SECTION 4.55(1A) APPLICATION - STATE SIGNIFICANT DEVELOPMENT APPLICATION NO. SSD-4972 Mod 7 - 161 SUSSEX STREET, SYDNEY – RESPONSE TO SUBMISSIONS

GL Investment Co Pty Ltd provides this response to the submissions received from various groups following advertisement of the Section 4.55(1A) Application State Significant Development Application No SSD-4972 Mod 7 for 161 Sussex Street, Sydney.

1 PUBLIC DOMAIN - LOWER GROUND (Wheat Road) - OVERALL PLAN
SCALE 1:200

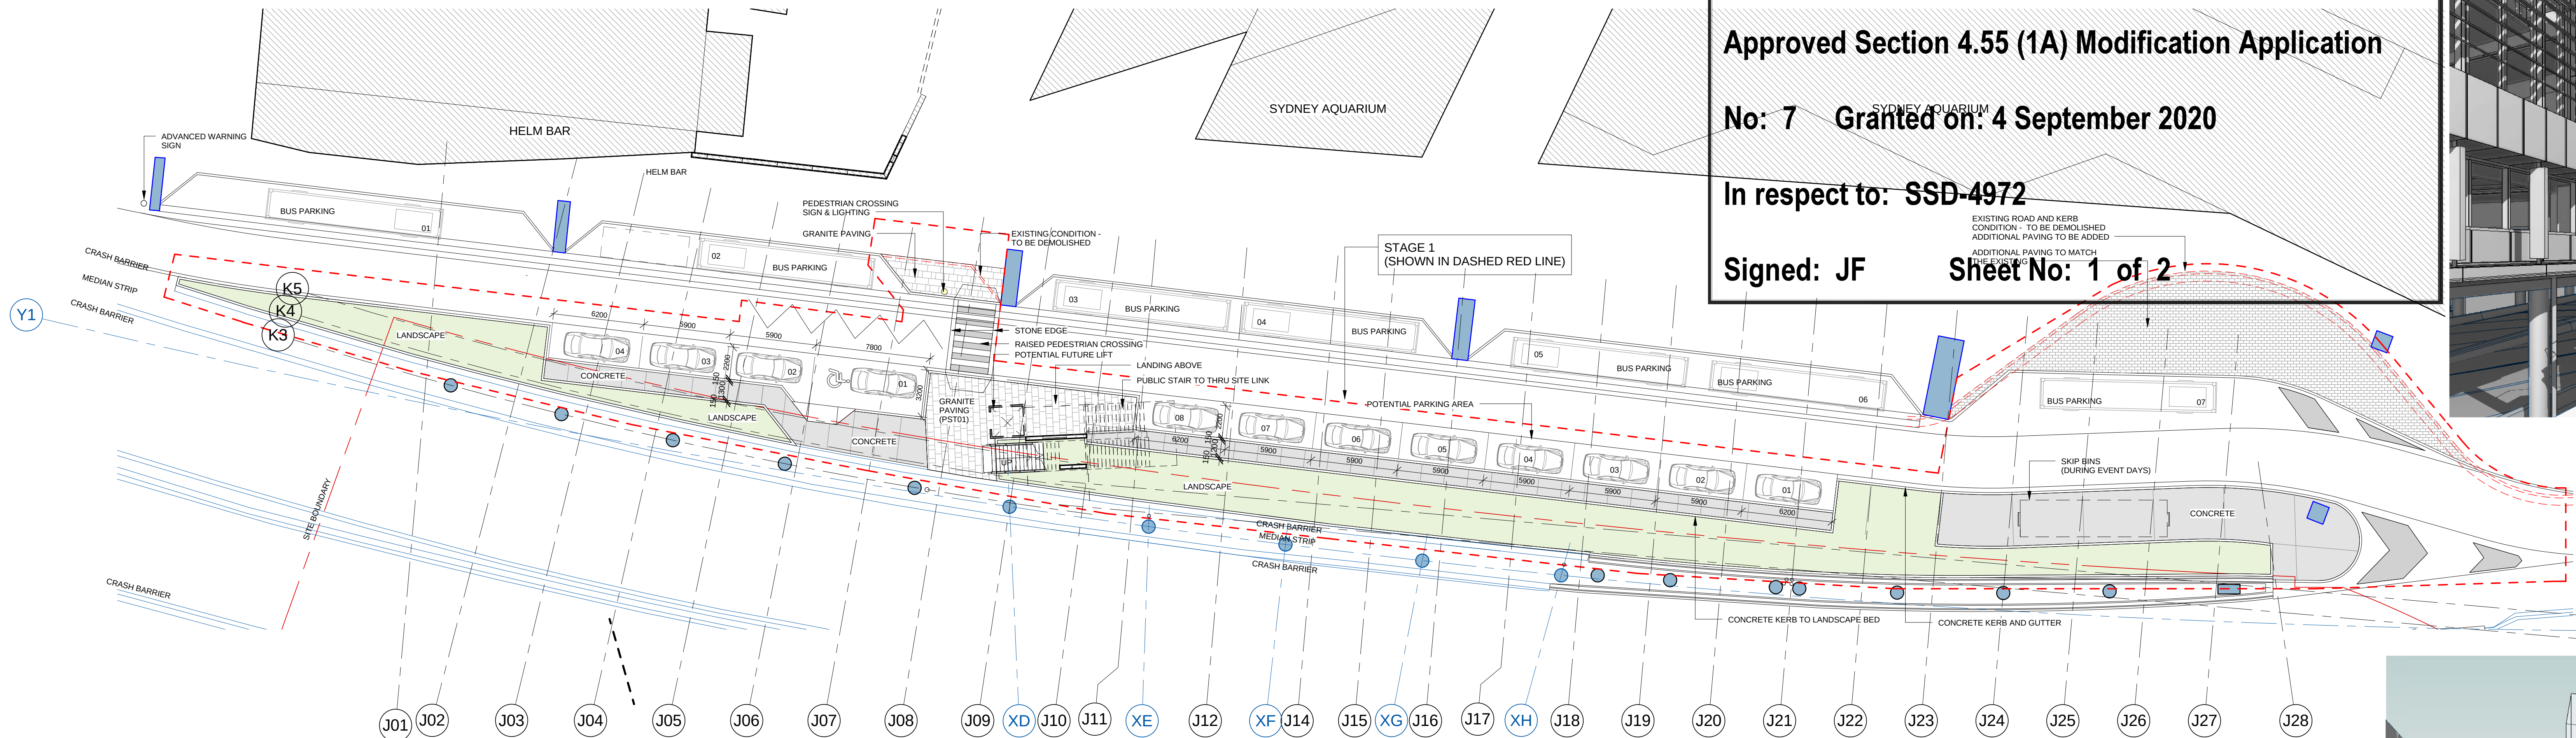
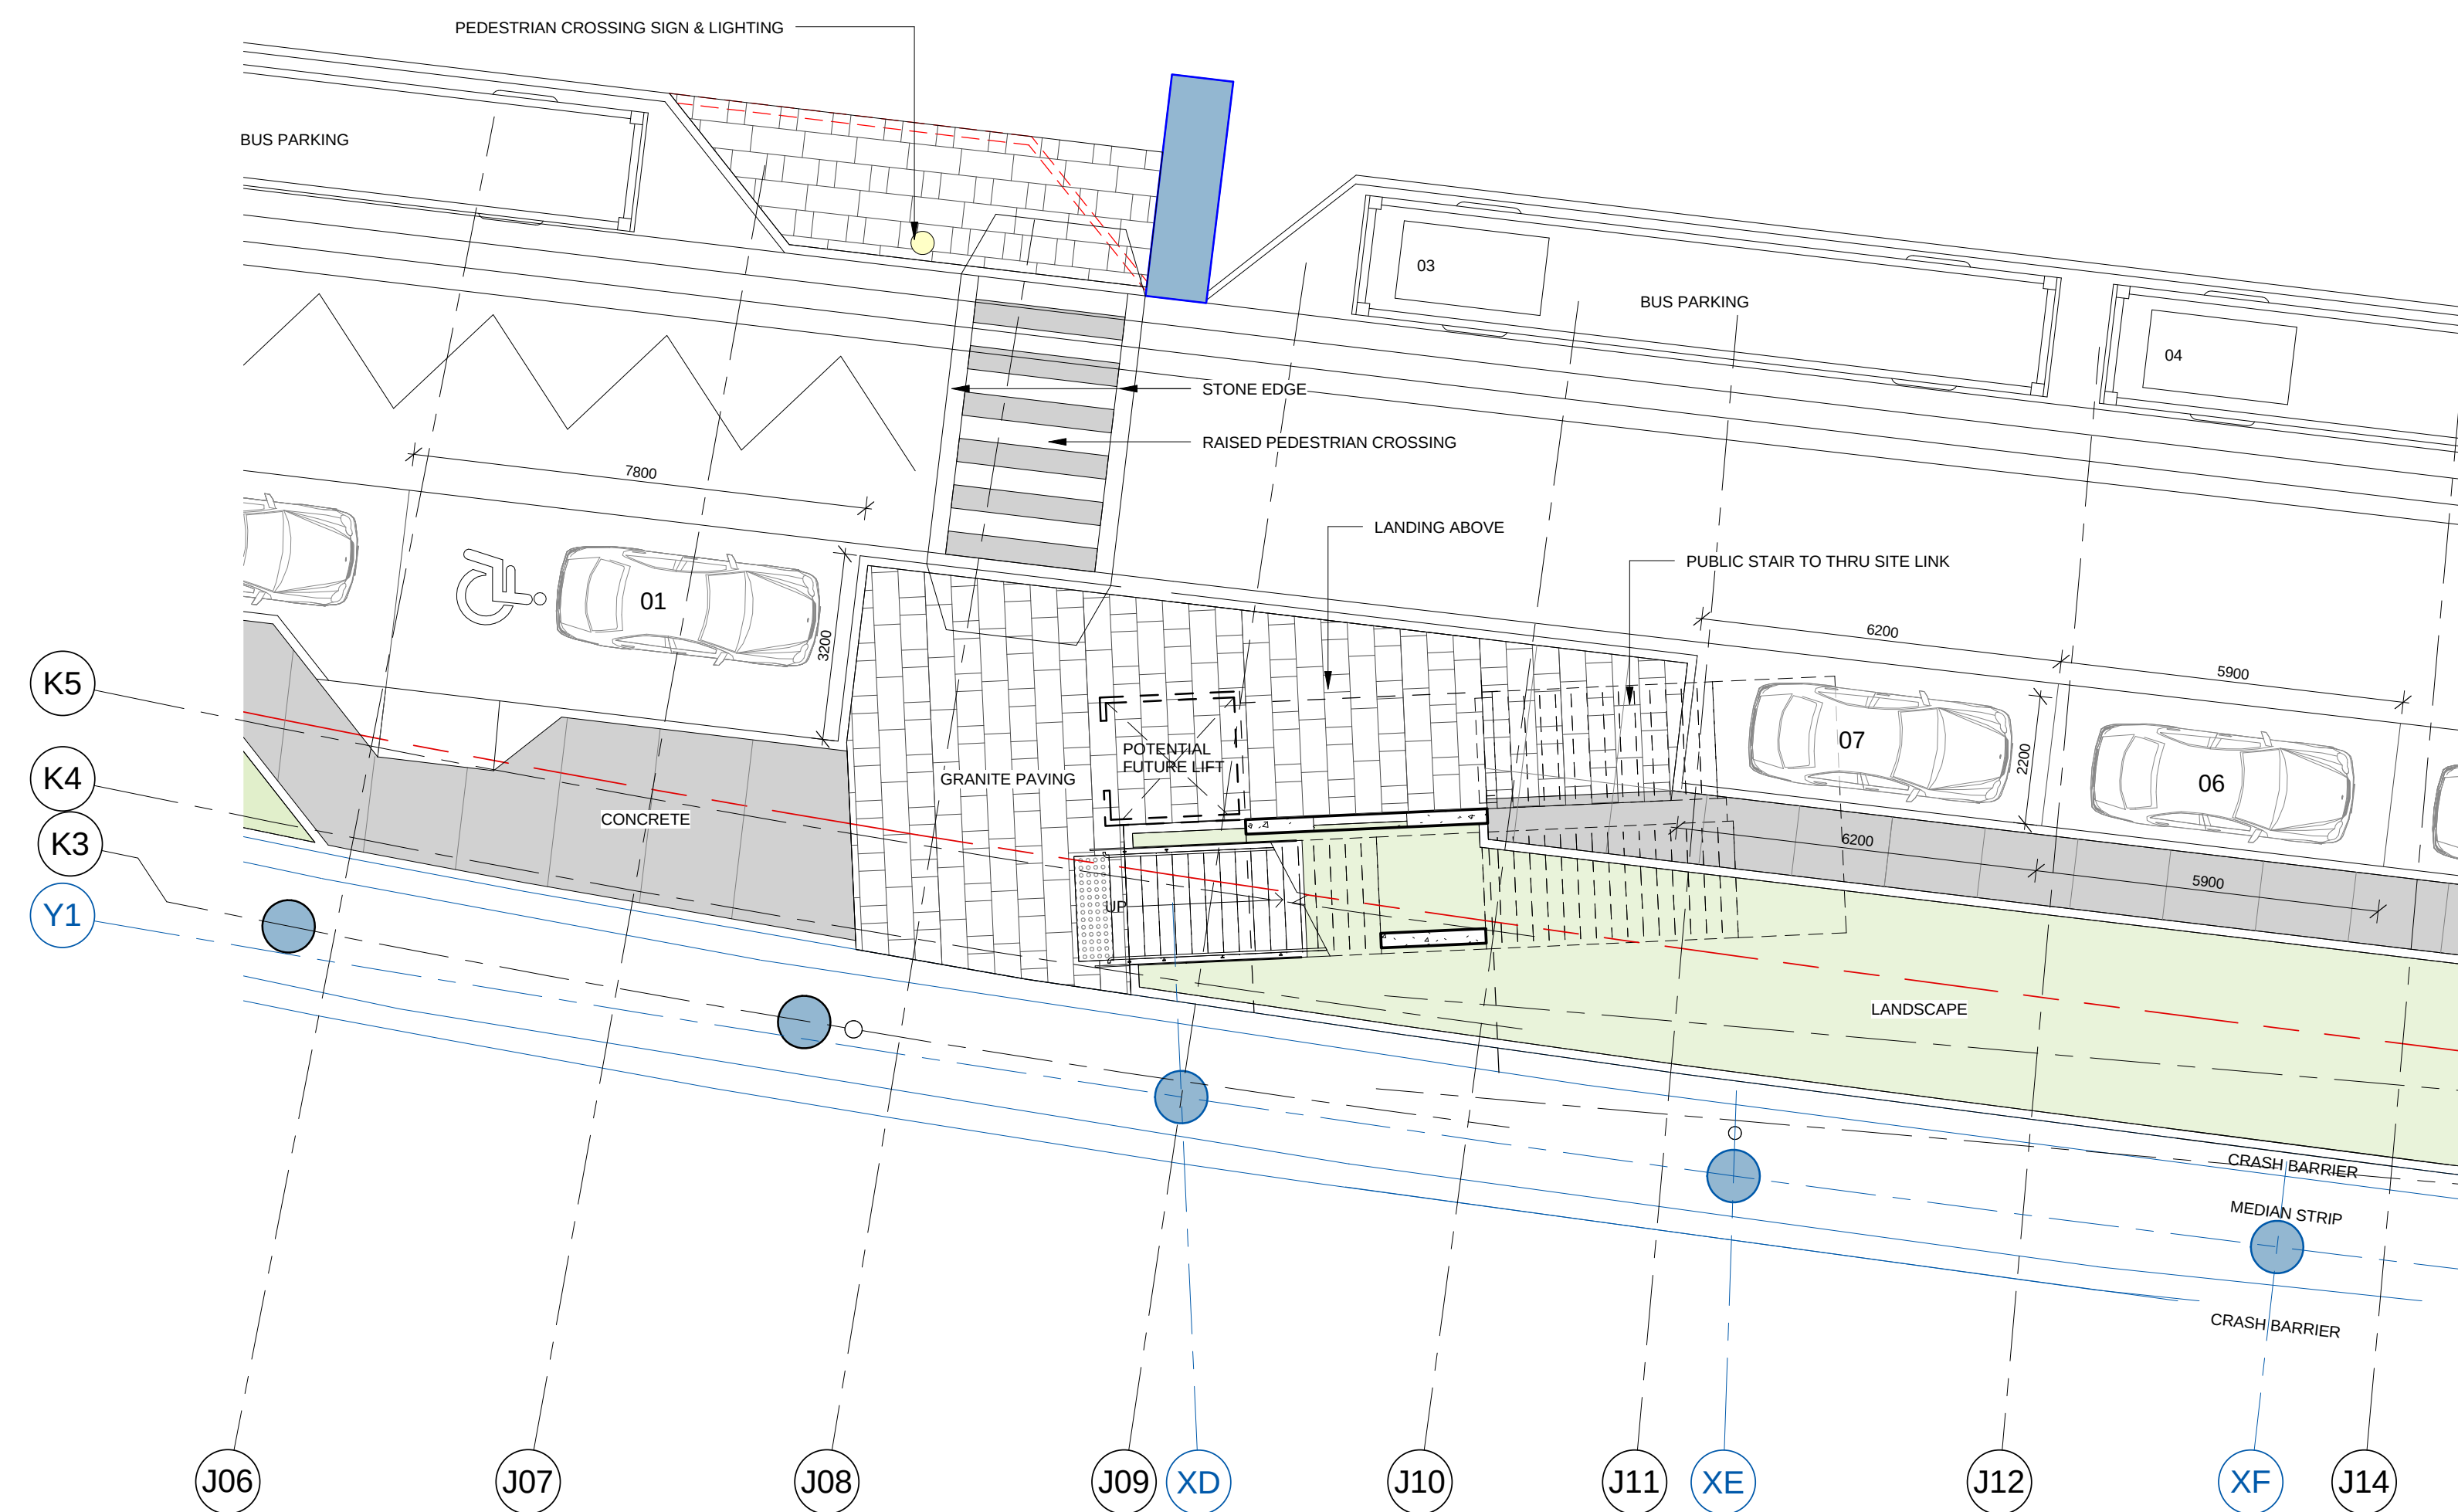
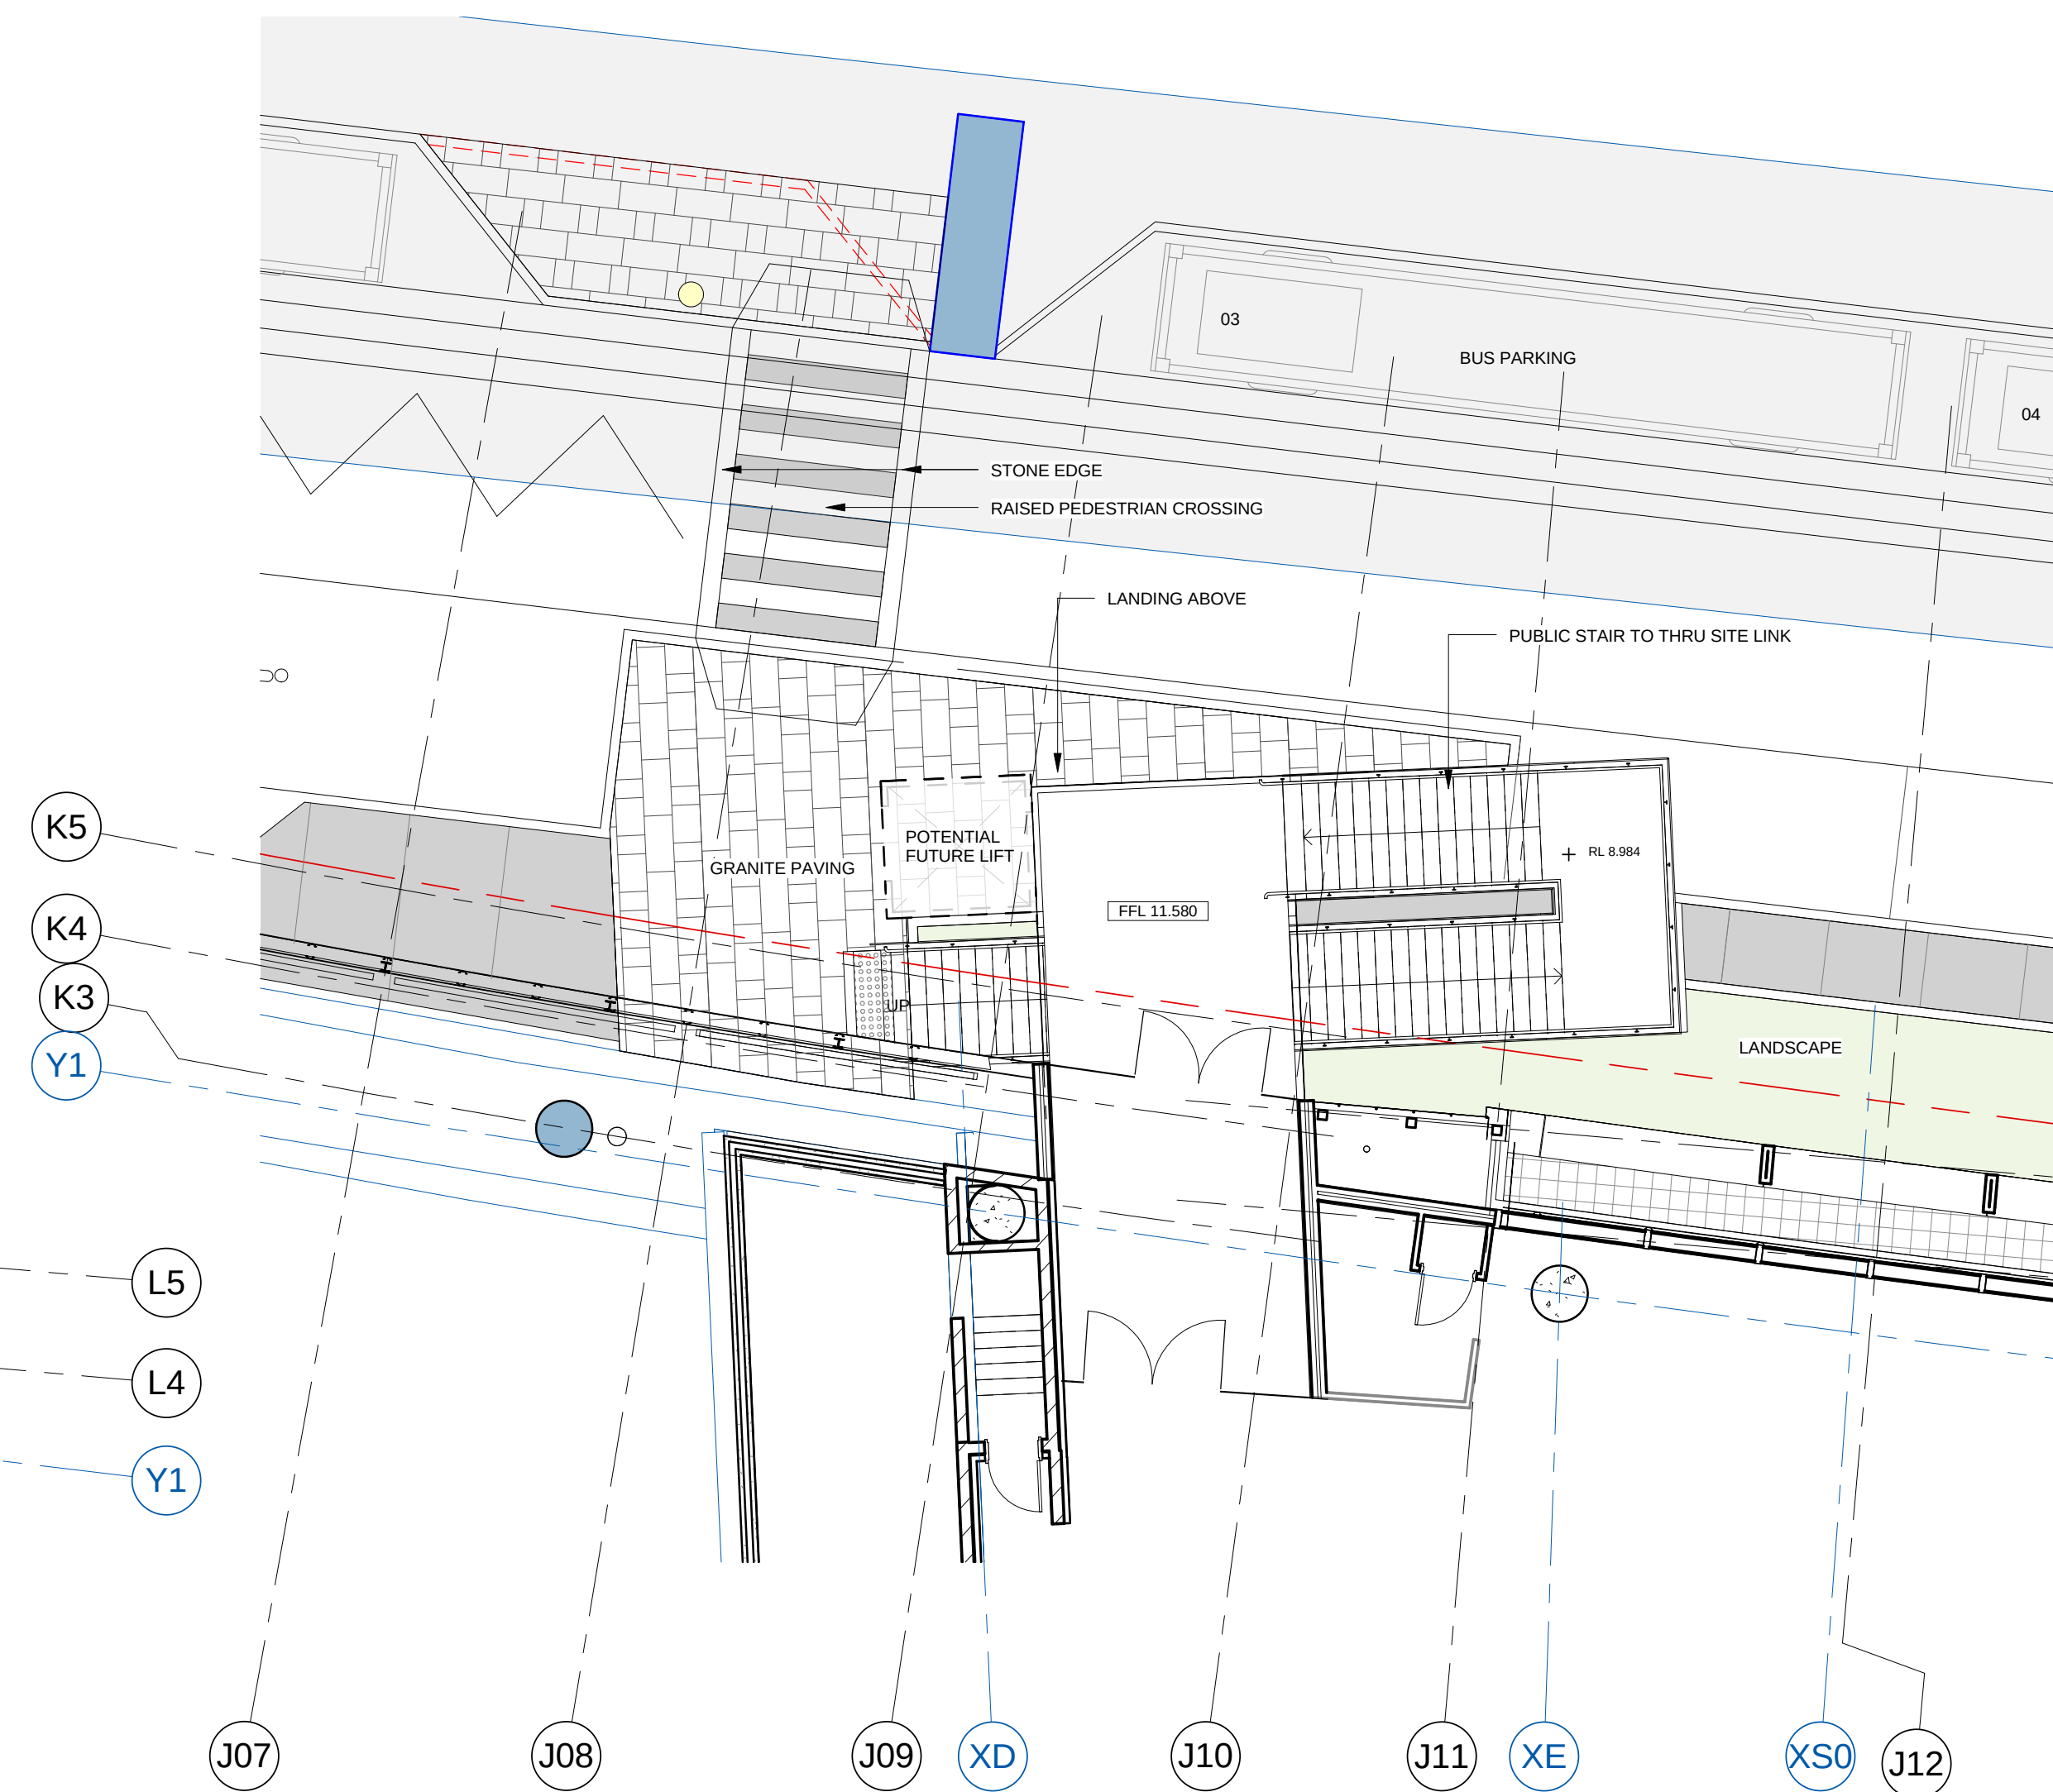
The TfNSW submission notes the reduction in bus parking bays and requires GL to consult the Sydney Coordination Office within TfNSW and BusNSW prior to preparing our response. Further they require GL to consider their advice and amend the design to provide more coach parking and address any safety issues.

2. Installation of lighting at or near the 'pedestrian access' sign for the safety of pedestrians; and
3. Updating of the vehicle/bus/pedestrian facility to be in accordance with Austroads Guidelines.

- Vehicle swept path diagrams showing that buses could safely use the coach spaces and vehicles use the adjacent vehicle spaces; and
- Confirmation if a 14.5 metre non-rear steer bus could be accommodated, and if not, the largest size bus that could.

Item / finding	TTW comment	Final applicant / GL response
TFNSW COMMENTS		
Consider the optional modifications and general maintenance works identified in the attached TTW Wheat Road Traffic Safety Review dated 4 February 2019;	Refer below	Refer below
Consider installation of lighting at or near the 'pedestrian access' sign for the safety of pedestrians; and	Refer attached JDG email dated 19 April 2020 (attachment F) recommending the following: • Install a directional flood light (where indicated in the email), directed to the centre of the pedestrian crossing and connect into an existing local lighting circuit This requires confirmation of the following:	GL agree to undertake these works subject to obtaining PMNSW and other relevant authority agreement

Provide confirmation if a 14.5 metre non-rear steer bus could be accommodated, and if not, the largest bus size that could.	See swept path analysis undertaken previously, refer attachment I	N/A
Develop construction management plans to maintain pedestrian movements along footways at all times during construction activities.	No construction activities are proposed.	N/A
TTW SAFETY REVIEW ITEMS		
Optional modification: Provide an additional convex mirror for the far north bus parking space	GL to advise on if these works will be undertaken.	YES

Item / finding	TTW comment	Final applicant / GL response
to improve sight distance to oncoming traffic.		
Optional modification: Adjust the height of the existing "Exit Speed 30km/h" sign to reduce the likelihood of being obscured and to improve sight distance for drivers.	GL to advise on if these works will be undertaken.	YES
General maintenance: Southern convex mirror should be adjusted and corrected.	GL to advise on if these works will be undertaken.	YES
General maintenance: Convex mirror south of the pedestrian crossing should be reinstated.	GL to advise on if these works will be undertaken.	YES
General maintenance: Pedestrian detour sign for 2014 – 2016 should be removed.	GL to advise on if these works will be undertaken.	YES
